City of Portland, Maine - Building or Use Permit Application
 389 Congress Street, 04101 Tel: (207) 874-8703, Fax: (207) 874-8716

Permit No: 05-1648	Issue Date:	CBL: 032 L002001
------------------------------	--------------------	----------------------------

Past Use: Commercial	Proposed Use: Commercial/ Tenant Fit-up/ install door to temple st. 1st flr	Permit Fee: \$66.00	Cost of Work: \$5,000.00	CEO District: 1
Proposed Project Description: Tenant Fit-up/ install door to temple st. 1st flr		FIRE DEPT: <input type="checkbox"/> Approved <input type="checkbox"/> Denied	INSPECTION: Use Group: Type	
		Signature:	Signature:	
PEDESTRIAN ACTIVITIES DISTRICT (P.A.D.)				
Action <input type="checkbox"/> Approved <input type="checkbox"/> Approved w/Condition <input type="checkbox"/> Denied				
		Signature:	Date:

New Exterior Door
Conveyance Partners
One City Center
Portland, Maine

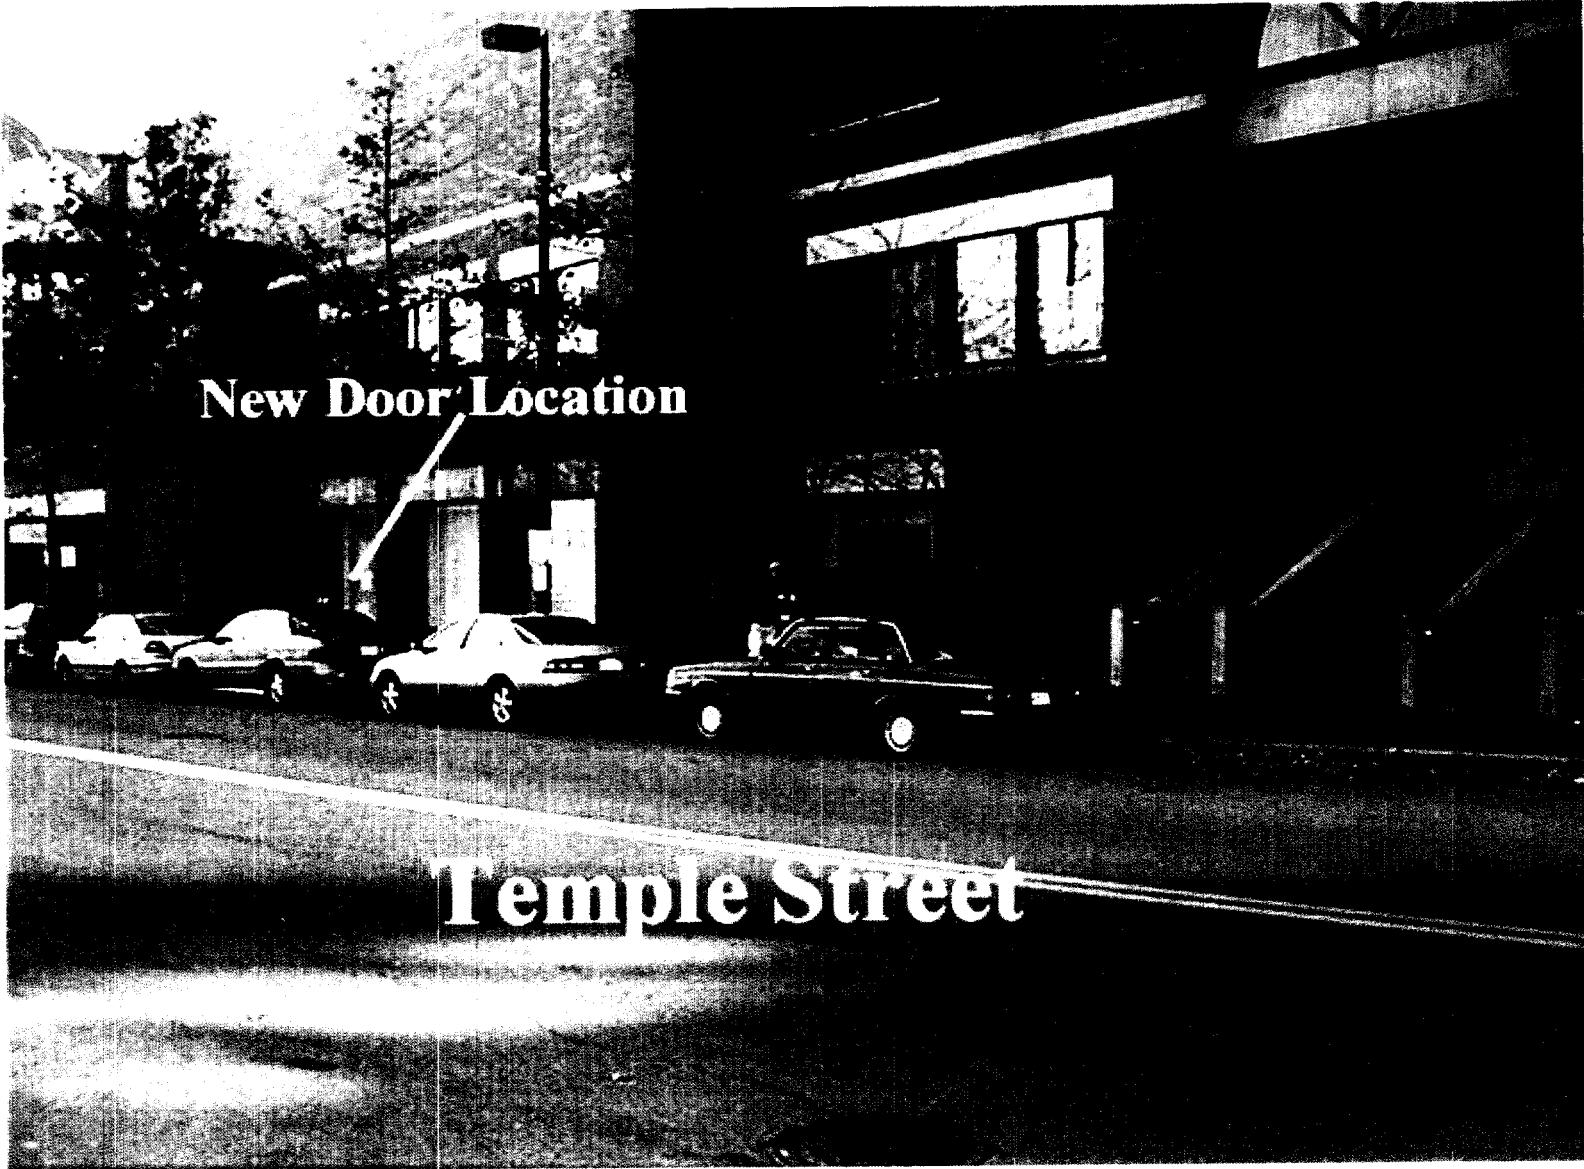
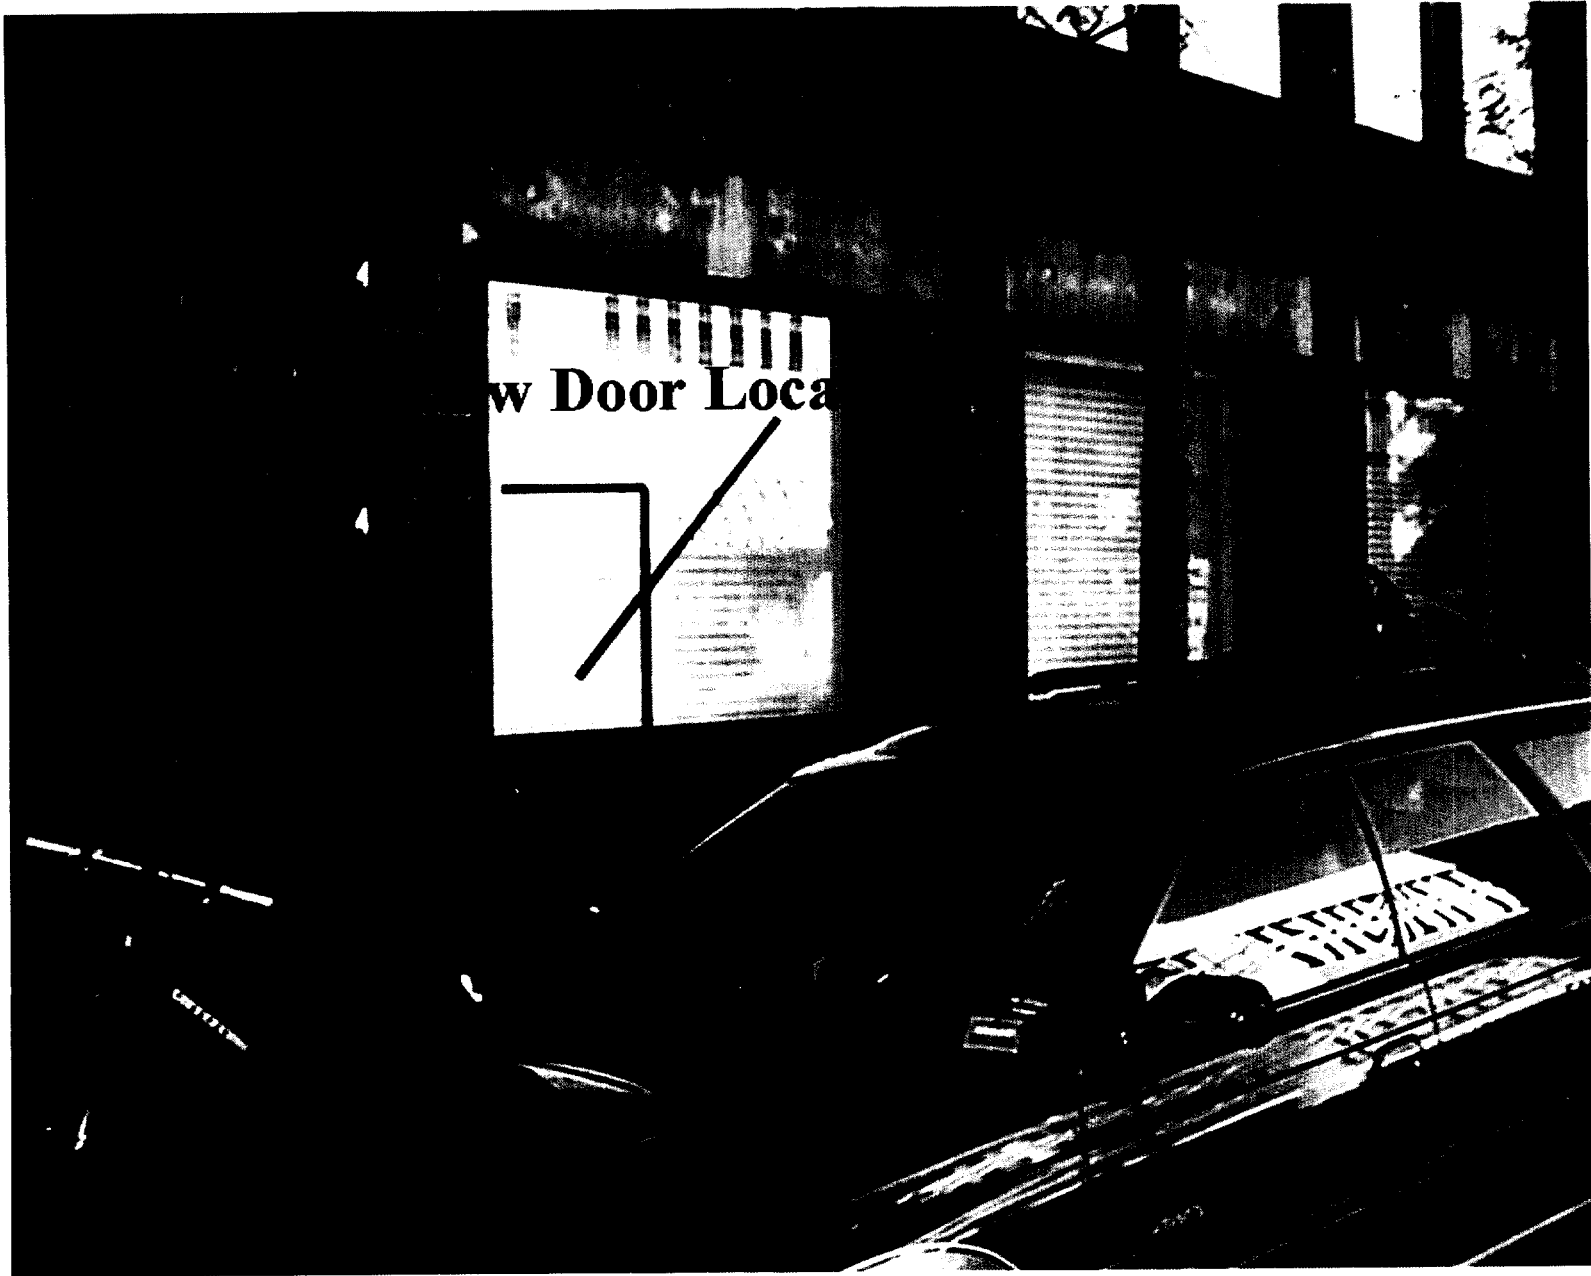
1) The exterior door must be recessed to NOT swing over the the sidewalk while swinging in the direction of travel . DMC has agreed and will submit plans for review prior to commencement.			
Dept: Fire	Status: Approved with Conditions	Reviewer: Cptn Greg Cass	Approval Date: 12/01/2005
Note:			Ok to Issue: <input checked="" type="checkbox"/>

Comments:
12/2/2005-mjn: Advised applicant door cannot swing over sidewalk...referred back to Fire to see if door can swing "in"
12/6/2005-mjn: Fire requires that the door swing out....cannot swing over side walk...permit on hold until redesign occurs, Left message with Al Knight.
